Response to Planning Application

From: Arun District Council Leisure & Greenspace

Application ref: WA/68/20/OUT

Location: Land west of Tye Lane Walberton

CONCEPT MASTERPLAN

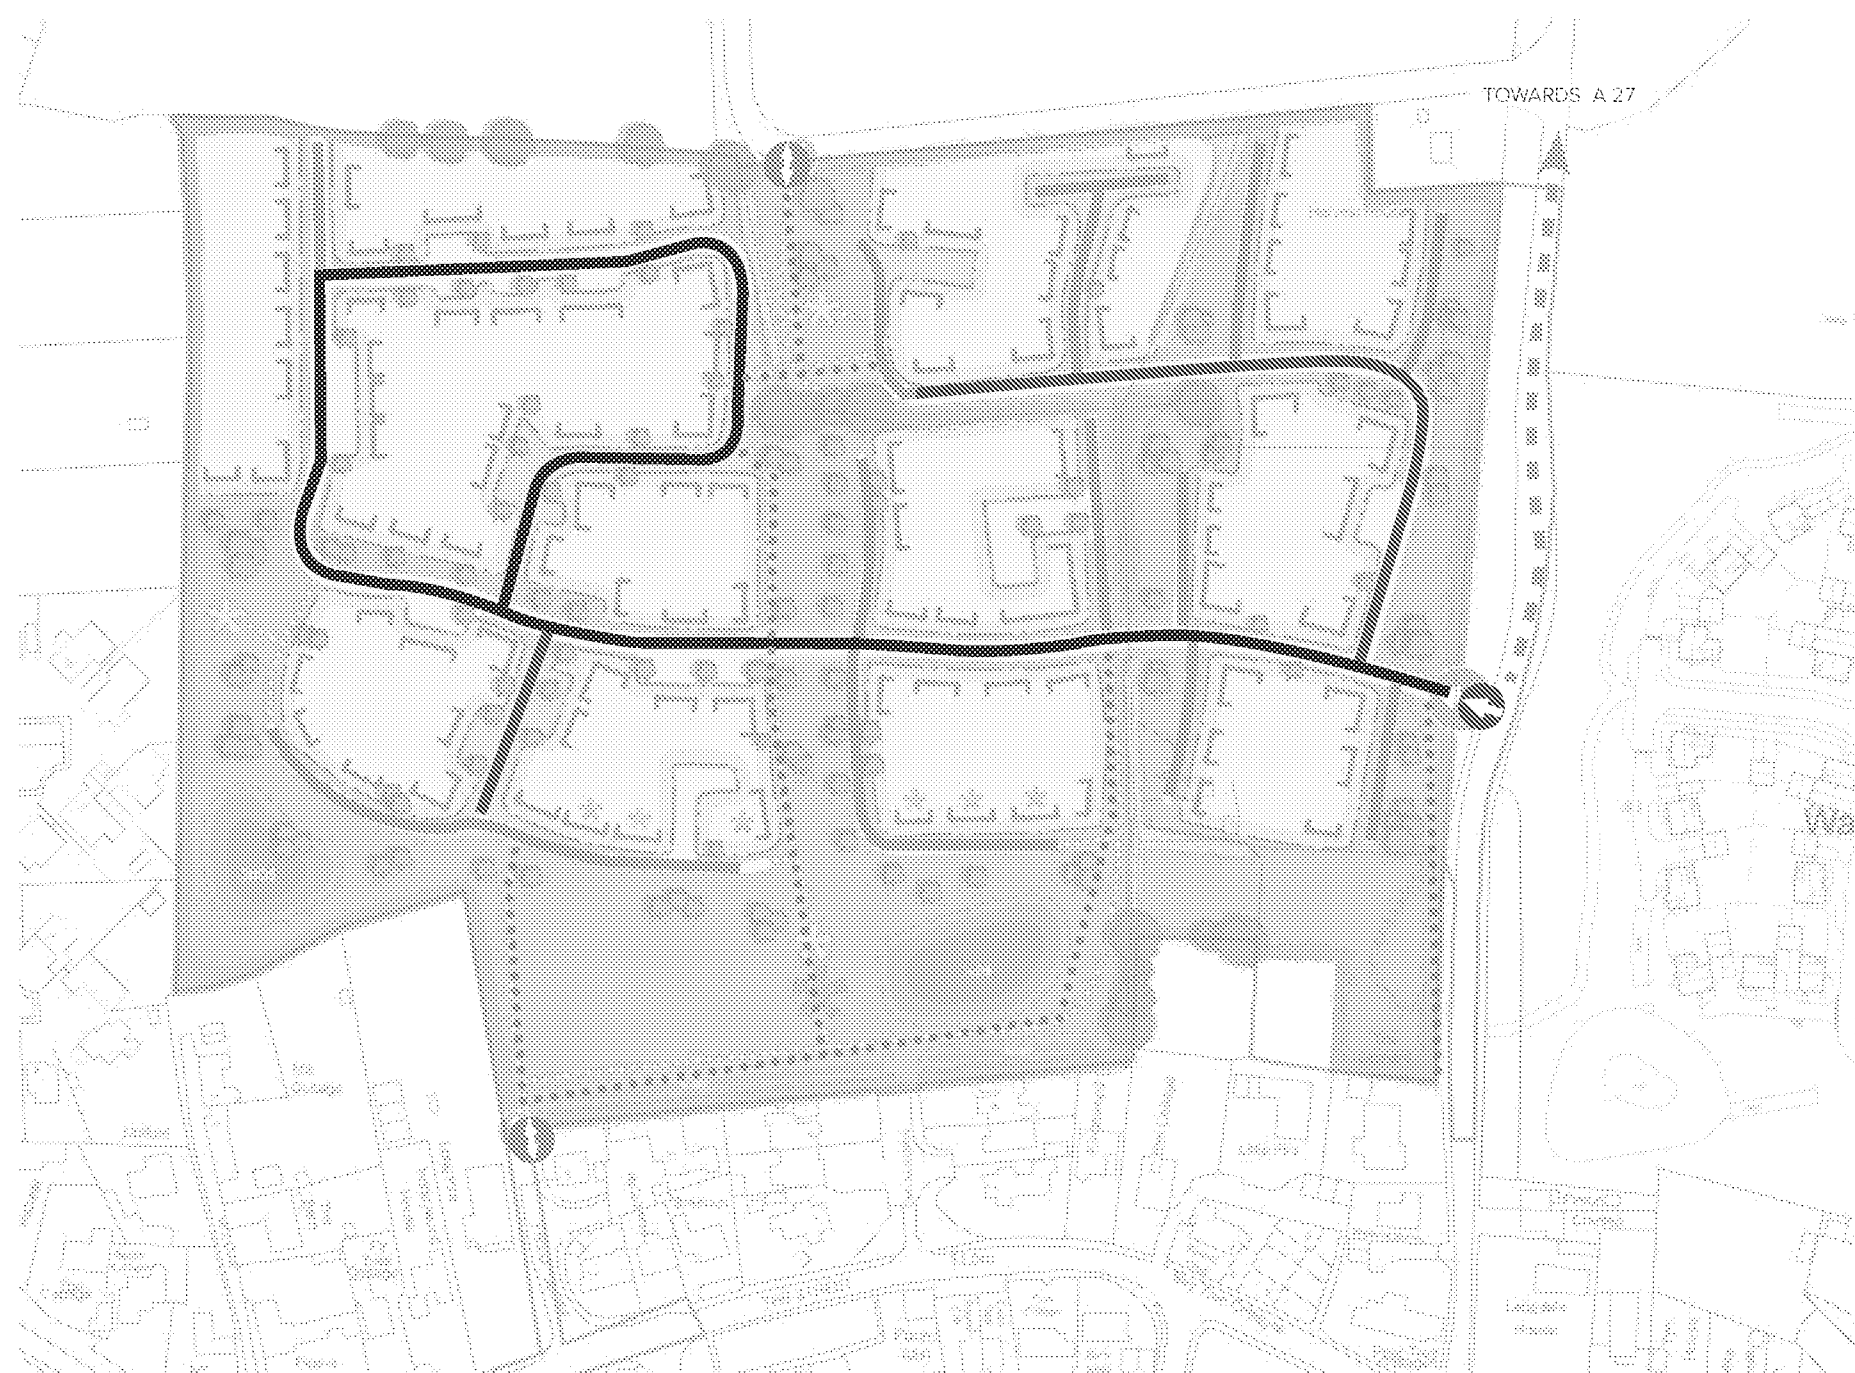
The information provided within Concept Masterplan 01 Dwg CMP- Rev P4 indicates a well-spaced site with good areas of POS both centrally and surrounding the areas of housing and a larger open area indicated to the south of the site. The indicative location of the areas of POS would appear to cater for the existing trees and hedges along the watercourse and those located within the site. Excluding the existing trees to the periphery of the site there would not appear to be a significant canopy cover in general with the exception of a few intermittent trees worthy of retention which must be protected and retained.

Quality, well-designed Public Open Space will be fundamental to any proposal submission, these will need to accord with Arun District Councils OS SPD January 2020. There would be requirement for confirmation of the areas of public open space being proposed with this development, and clarification re quantum. The Concept Masterplan indicates where the areas of POS are being proposed for this development which is

good to see. Our SPD January 2020 would require 12,788m² as a minimum of well connected, usable, quality POS provision within this development.
